## MEMORANDUM

DATE: February 3, 2020

SUBJECT: MS-20-001 – DeYoung Subdivision (Mancave Storage)  
First Submittal

**DEVELOPED DRAINAGE PLAN**

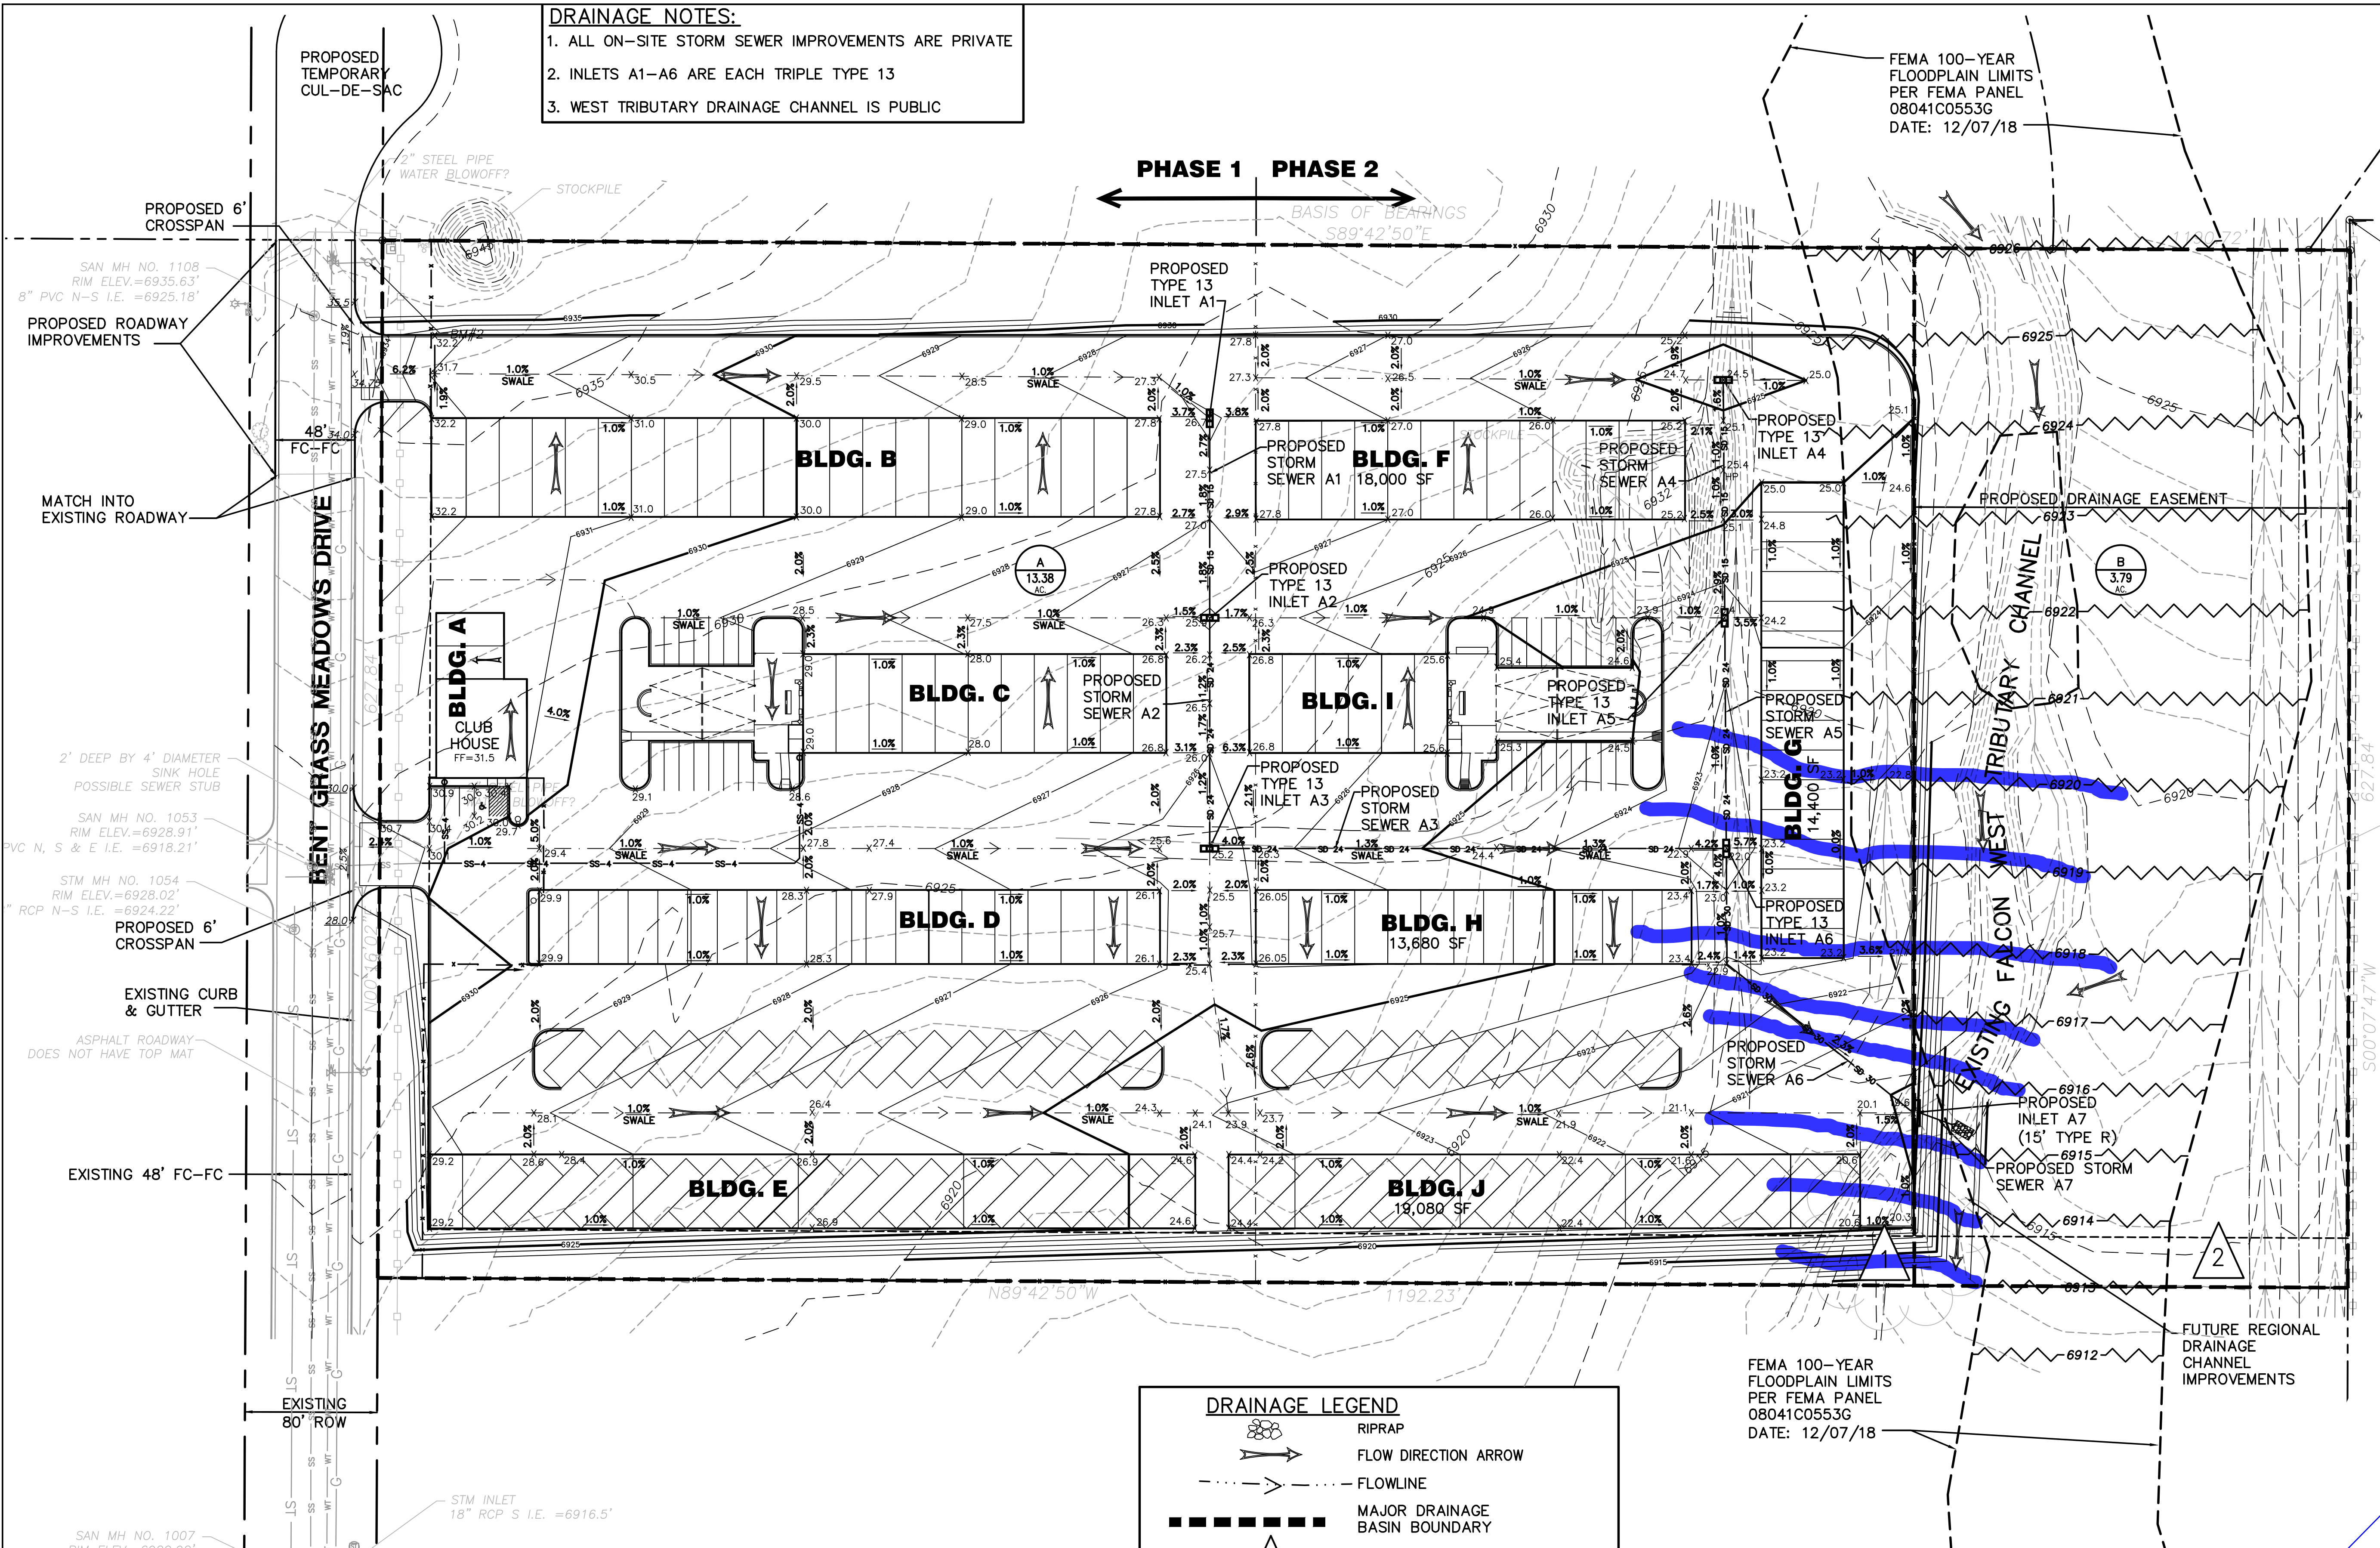
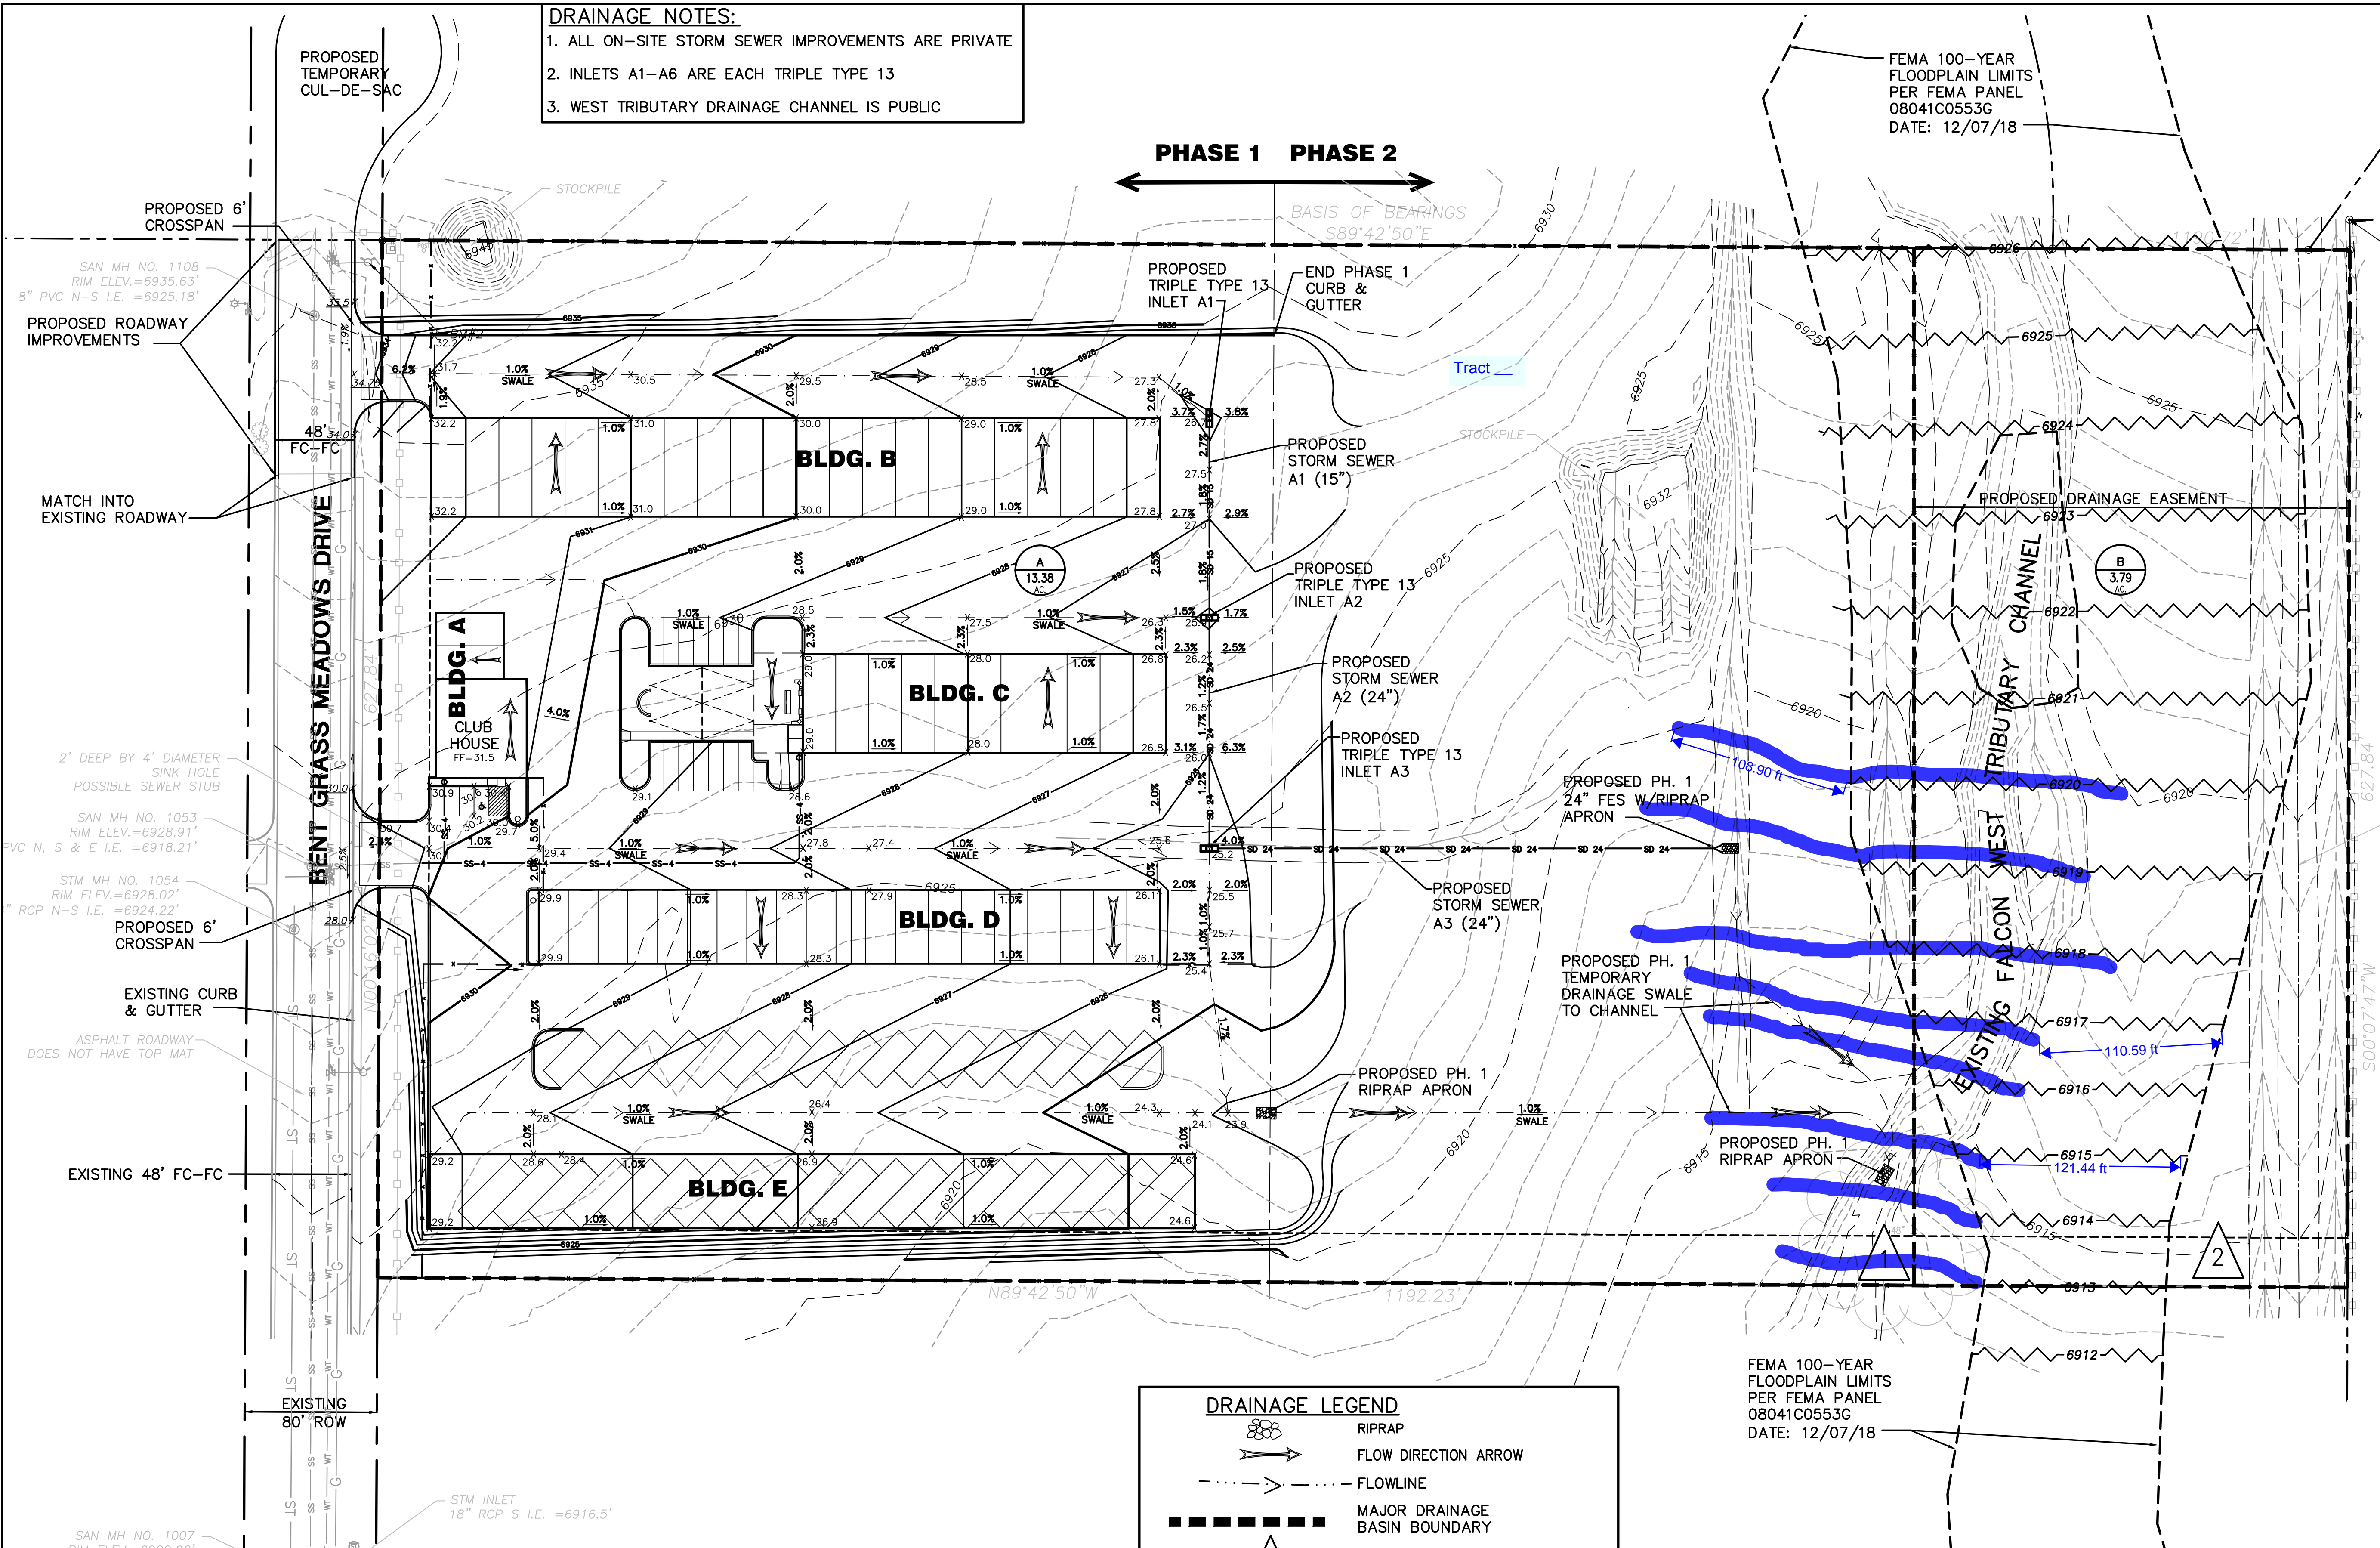
1. Water Quality Capture Volume (WQCV) at a minimum is required for the site (as stated at the EA meeting) prior to discharging runoff to the channel (waters of the State); downstream drainage easements (or other documentation of acceptance) are required for any increase in runoff to those properties. Revise the drainage plans and report as appropriate.

2. The FEMA floodplain appears to be 110-120 feet east of where it should be based on the existing contours (see redlines). Provide additional drainage easement(s)/tract(s) to cover actual 100-year flood areas outside of the FEMA floodplain boundary. If the Regional Floodplain Administrator approves any changes to where the floodplain is shown, revise as appropriate.

5. Address whether the proposed development will increase peak flows (will the times of concentration for the site and the upstream basin coincide?) through the two downstream properties, and the necessary drainage easements and channel maintenance entity. The existing downstream detention pond (Pond WU, offsite) and proposed repairs/completion by Bent Grass Residential Filing 2 need to be discussed in
